Address: 1, LOWER COMMON LANE, SCISSETT, HUDDERSFIELD, HD8 9HL

Application number: 2026/62/90452/E	
What is the application for?:	Erection of dwelling and associated works
Address of the site or building:	Land adj, Lower Common Lane, Scissett, Huddersfield, HD8 9HL
Postcode:

Proposed Rear Elevation (South east) 1:100

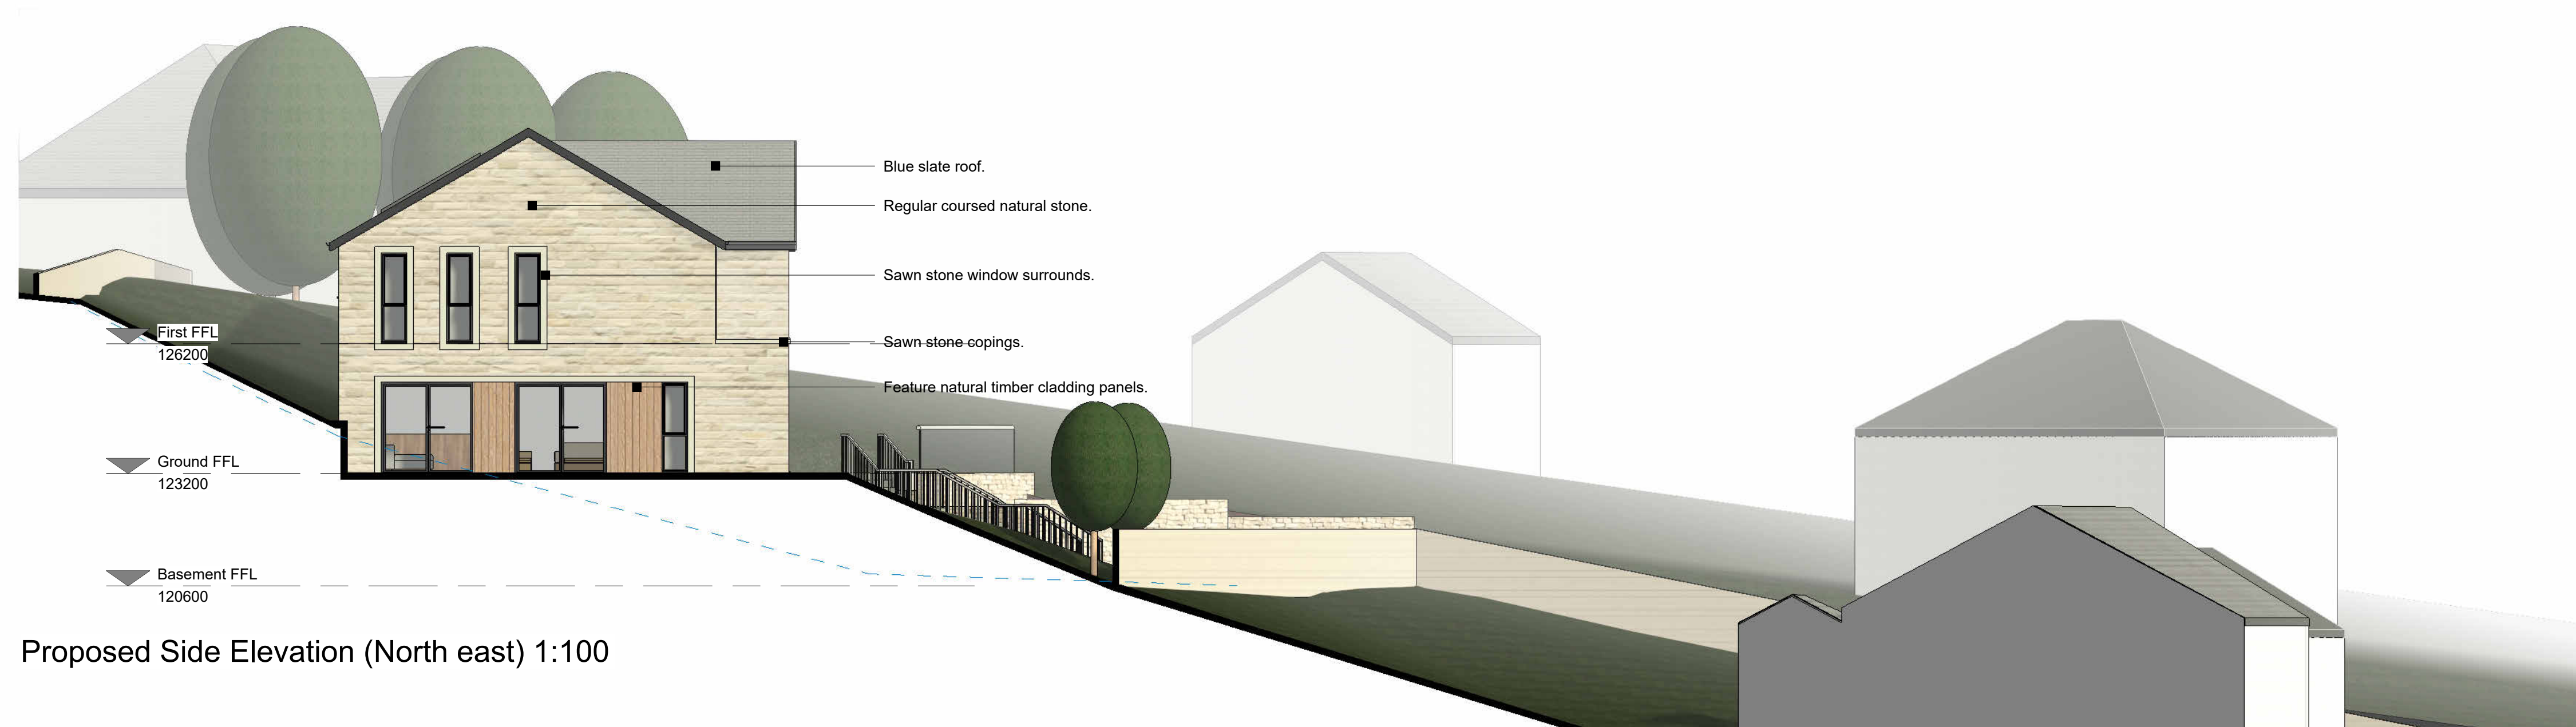
Type of comment: An objection	
Do you wish your comments to be published on the website anonymously?	No
<p>We wish to highlight the issue of undue loss of privacy raised by the design and location of this planning application. The scale of the building and height will overshadow our entire rear garden causing undue harm to our amenity. The proposal has a wrap around patio area, on three sides with glass balustrade. This patio will lift people above normal ground level and able to see into the garden over the existing boundary fence and shrubbery. There is also a conservatory on this side of our bungalow which will no longer be a private space. The site of this proposed dwelling is on a slope sitting high above us and the design will give us a powerful feeling of being overlooked. The time spent on such a patio leads to direct sustained viewing and possible noise disturbance although unintentional it will lead to detrimental overlooking and create an overbearing atmosphere. Our patio area outside the conservatory where we eat regularly and entertain will no longer be our private place nor will any other part of our rear garden as the proposed dwelling will fill the entire width of our boundary. The proposal boasts a generous amount of amenity space and private garden whilst not considering that our amenity space and privacy will be greatly affected. Its dominance will change the character of the bungalow and garden and affect the outlook from habitable rooms.</p> <p>Our mental health and wellbeing(something Nortonthorpe Sports Club feature greatly in their supportive information) will be adversely affected both during construction and far beyond if this proposal goes ahead. The environmental impact on this area will be huge, the site is some distance from Lower Common Lane making it a perfect quiet place for wildlife much of which visits our garden regularly another amenity we would lose.</p> <p>This proposal has no consideration of impact on neighbouring properties and would result in poor and reduced outlook leaving a feeling of being unduly hemmed in.</p> <p>Kirklees Key Design Principal 6 LP24 Protect the privacy of existing neighbours</p> <p>The mass of this building does not conform with surrounding topography and neighbouring buildings there we strongly object to this proposal</p>
